## **FIRE RISK MANAGEMENT, INC**

# **Memo Report**

**Subject: Code Review and Life Safety Evaluation; ICW Building Located at  
519 Congress St., Portland, ME**

NO.	REVISION'S	DATE	BY
THIRD FLOOR PLAN			
SCALE: 1/4" = 1'-0"			
PLANS SHOWING CHANGES TO STAIRS AND ADDITION OF ELEVATOR ENCLOSURE AT THE			
MAINE CHARITABLE MECHANIC'S ASSC. 519 CONGRESS ST. PORTLAND, ME.			
17 SEPT 66	MILLER & BEAL INC.		SHEET
	ARCHITECTS		3
	PORTLAND, MAINE

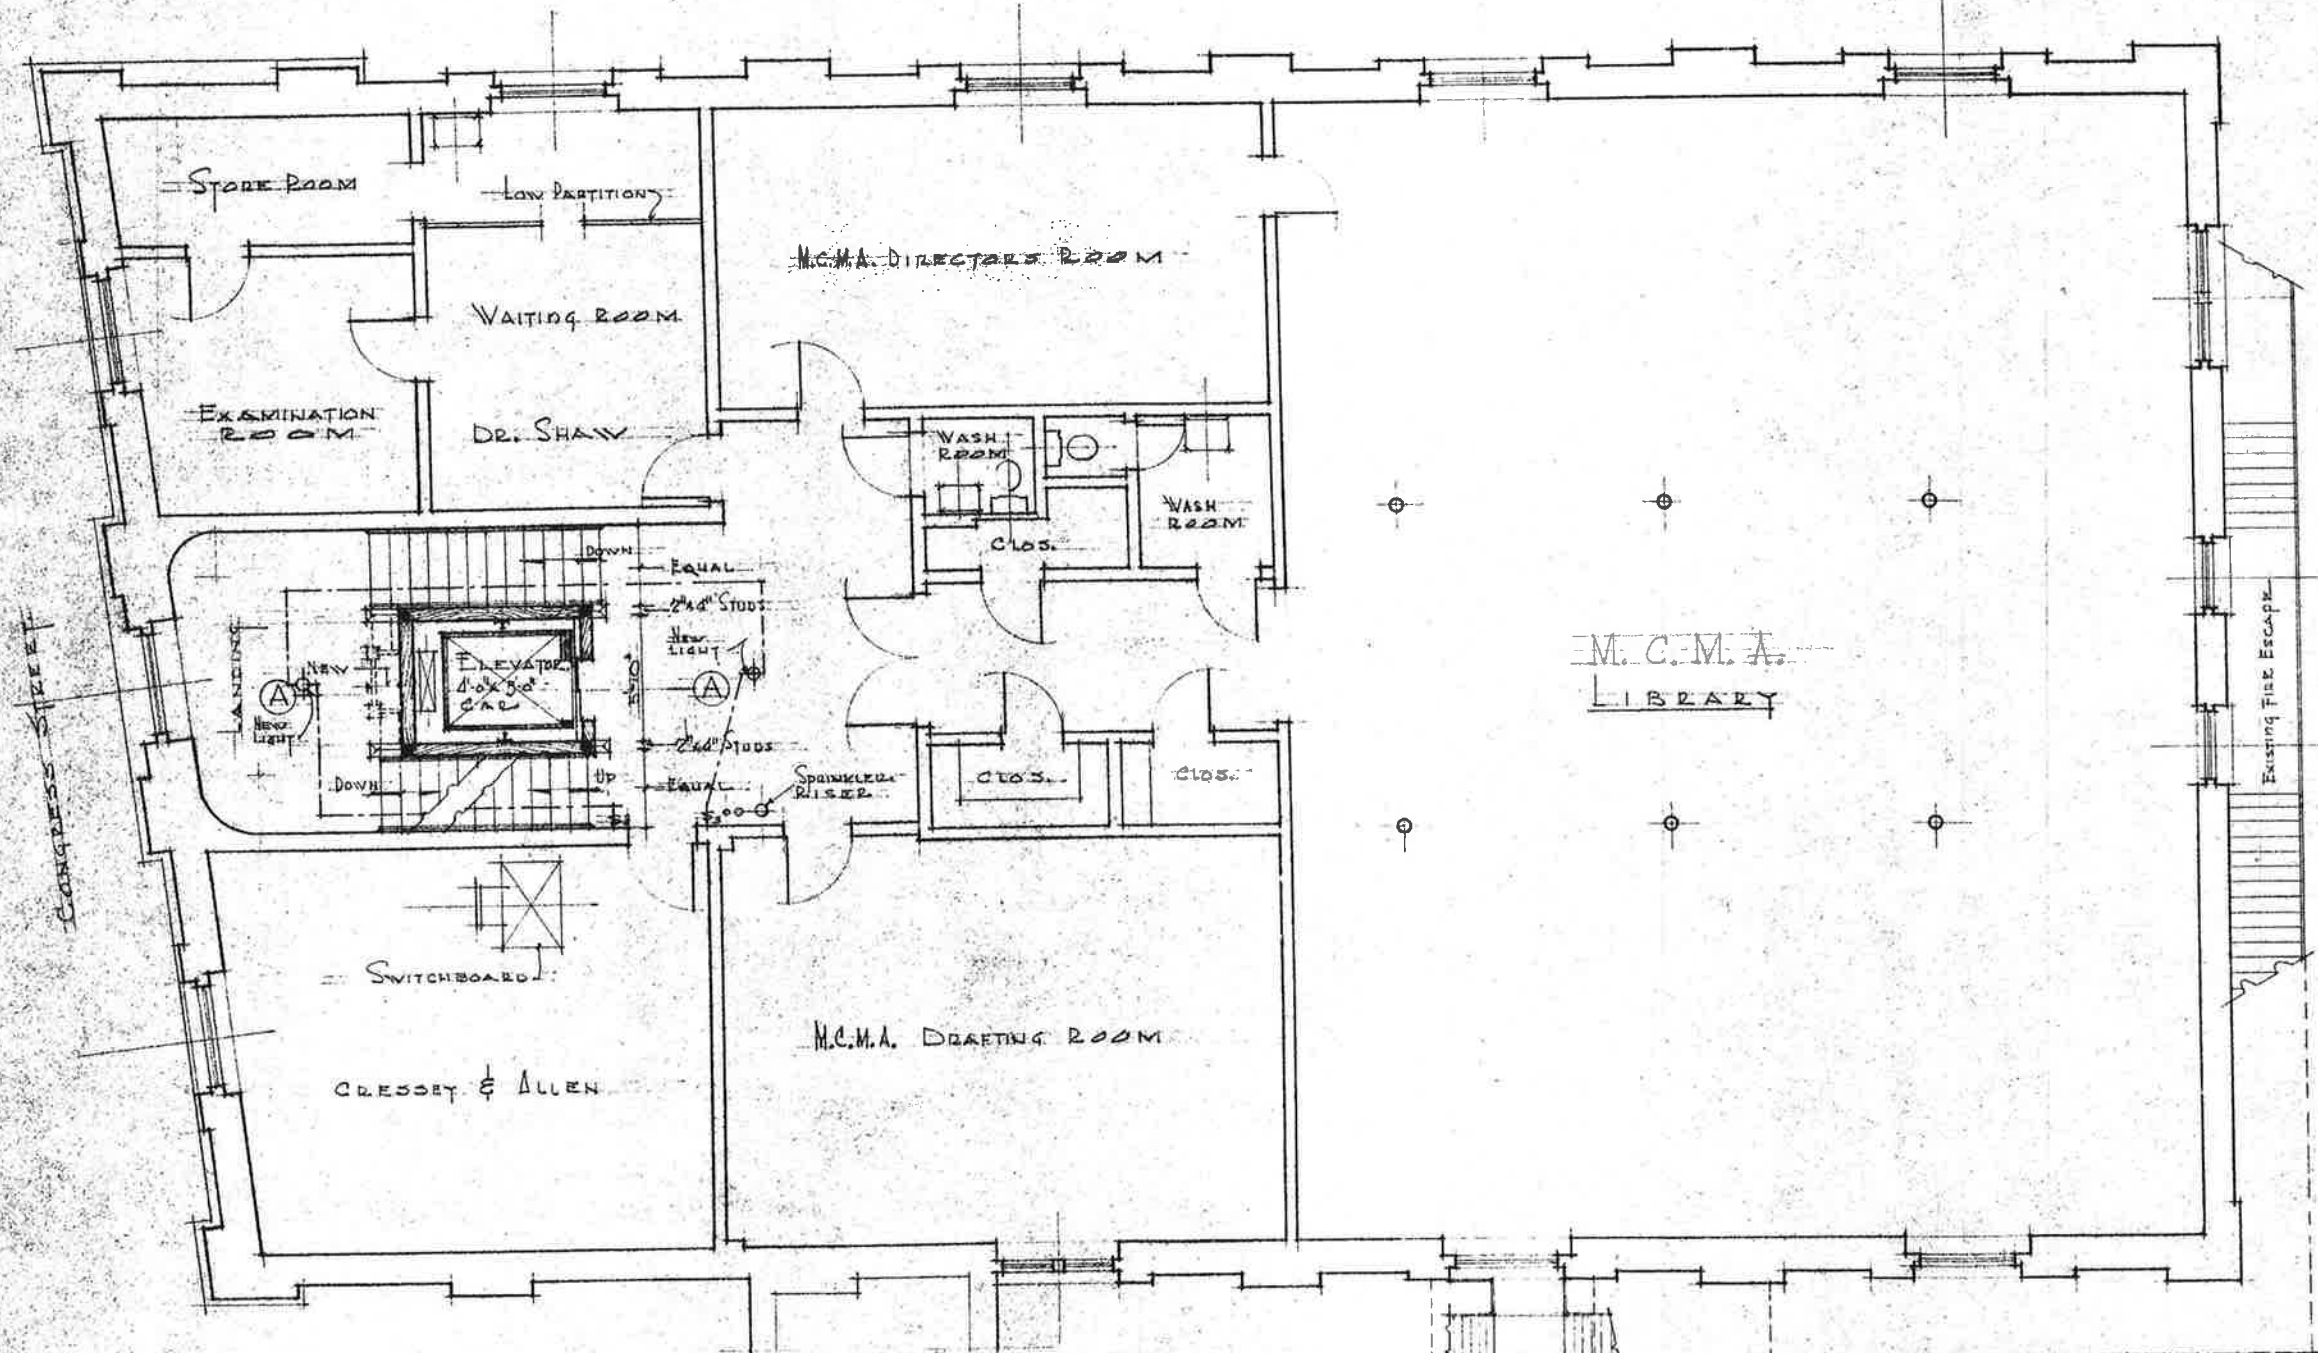
Due to the limited capacity of the means of egress in this building, it is recommended that any public event that is held in the ballroom be limited to no more than 160. Although this is likely a conservative limit that could safely accommodate events in this area, it does represent a strict compliance with existing codes; albeit not taking into account the “historic” nature of the building. If it is desired that a larger occupant load be used for this area, a more detailed egress analysis can be performed that will likely be able to demonstrate that this occupant load value can be safely increased. However, it would be recommended that prior to performing any such evaluation, concurrence be obtained from City officials that they would be willing to accept the results of such an analysis.

NO.	REVISIONS	DATE	BY
SECOND FLOOR PLAN			
SCALE: 1/4" = 1'-0"			
PLANS SHOWING CHANGES IN STAIRS AND ADDITION OF ELEVATOR ENCLOSURE AT THE			
MAINE CHARITABLE MECHANICS ASS'N.			
519 CONGRESS ST. PORTLAND, M.E.			
175	SEP 86	MILLER & BEAL INC.	SHEET
		ARCHITECTS	2
		PORTLAND, MAINE

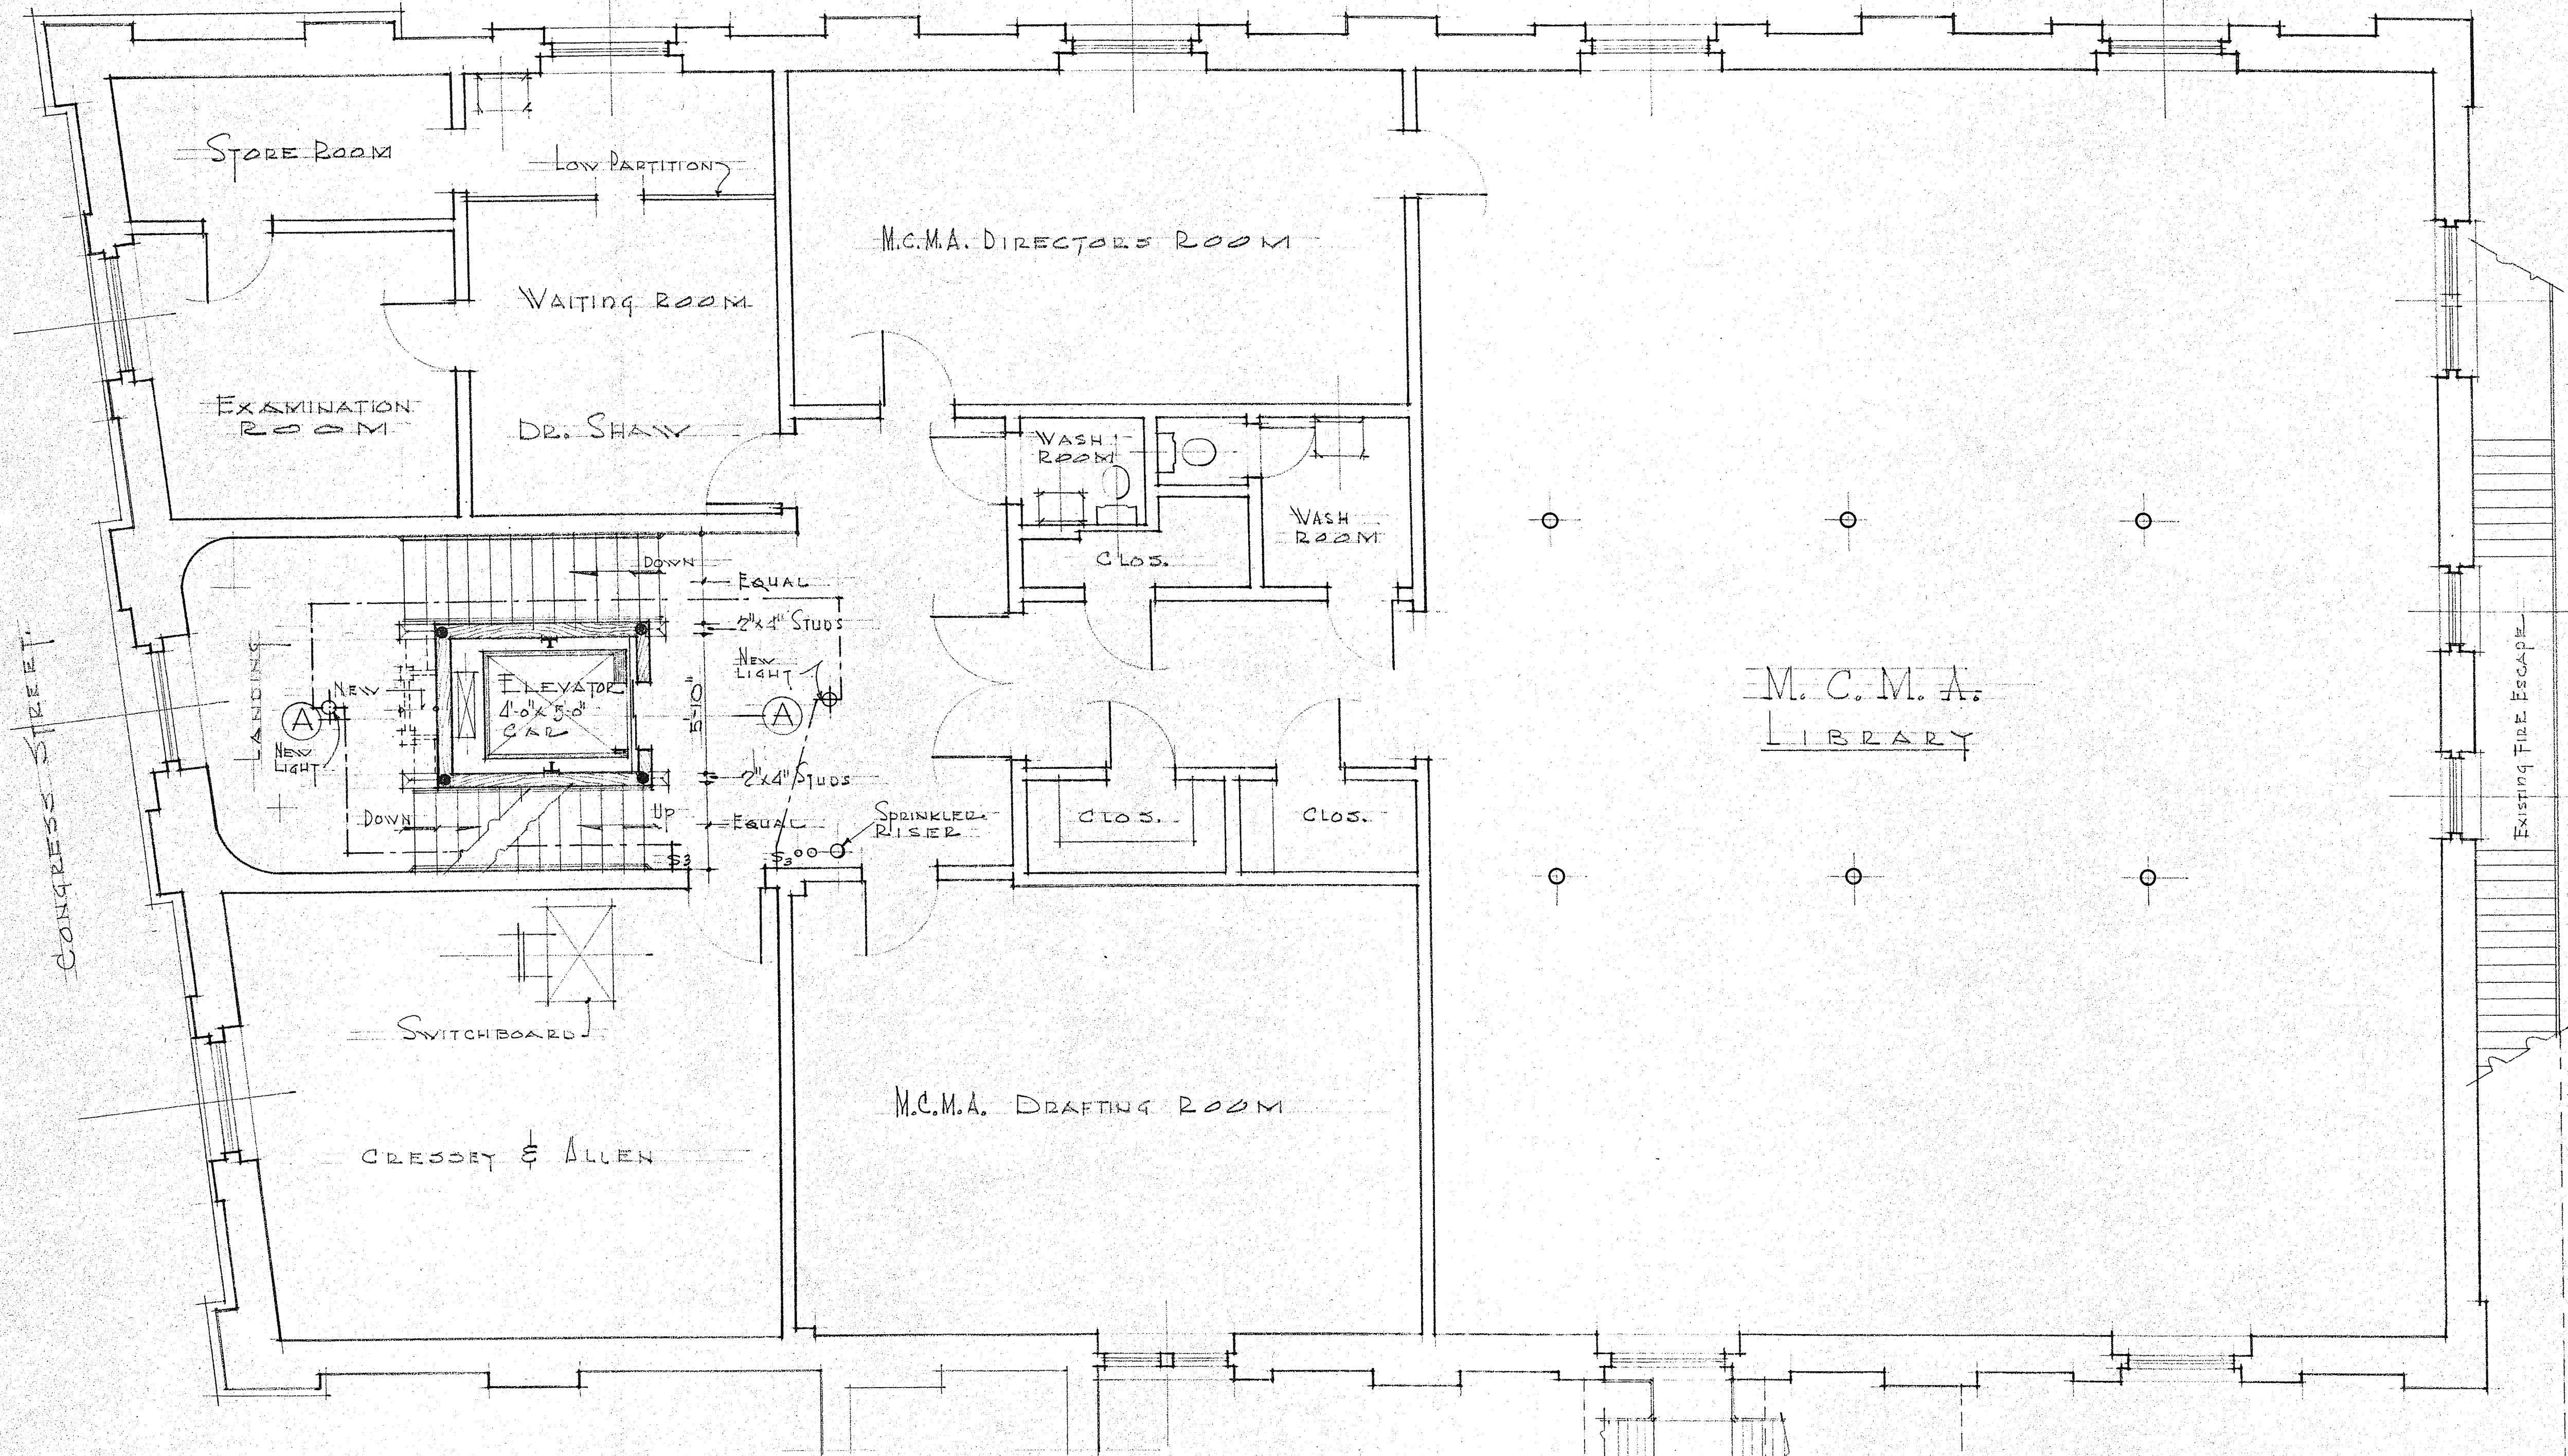
The 2<sup>nd</sup> floor meeting area can be safely used to support small meeting and/or training (classroom) type events. Based on the actual area of the room, the maximum occupant load for this room was estimated as 56. However, since this room is only provided with a single means of egress<sup>2</sup>, it is recommended that any event within this room be limited to no more than 50 occupants; thereby continuing to comply with current code requirements.

<sup>2</sup> Although this room is provided with two separate doorways, they are located immediately adjacent to one another and do not meet the NFPA requirements for separation of means of egress. As such, they must be considered as a single means of egress.

# Building Sketch

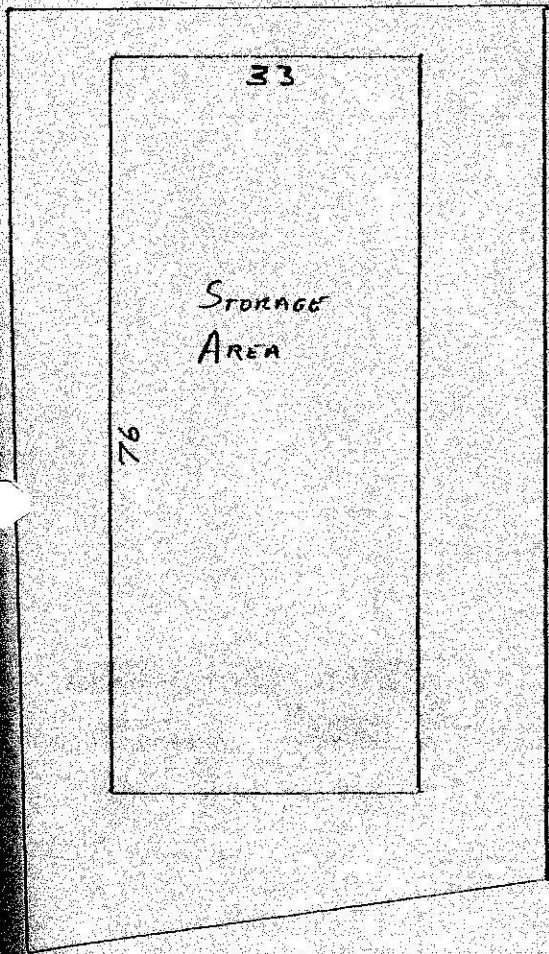
Based on the total travel distance from the 4<sup>th</sup> floor area to an exit, coupled with the fact that it is provided with only a single means of egress and the common path of travel significantly exceeds that allowed by code, it is recommended that this area not be used to support any public events. If a secondary means of

egress can be provided, such as extending the existing fire escape to this level, then it would be possible to safely use this area for that purpose.
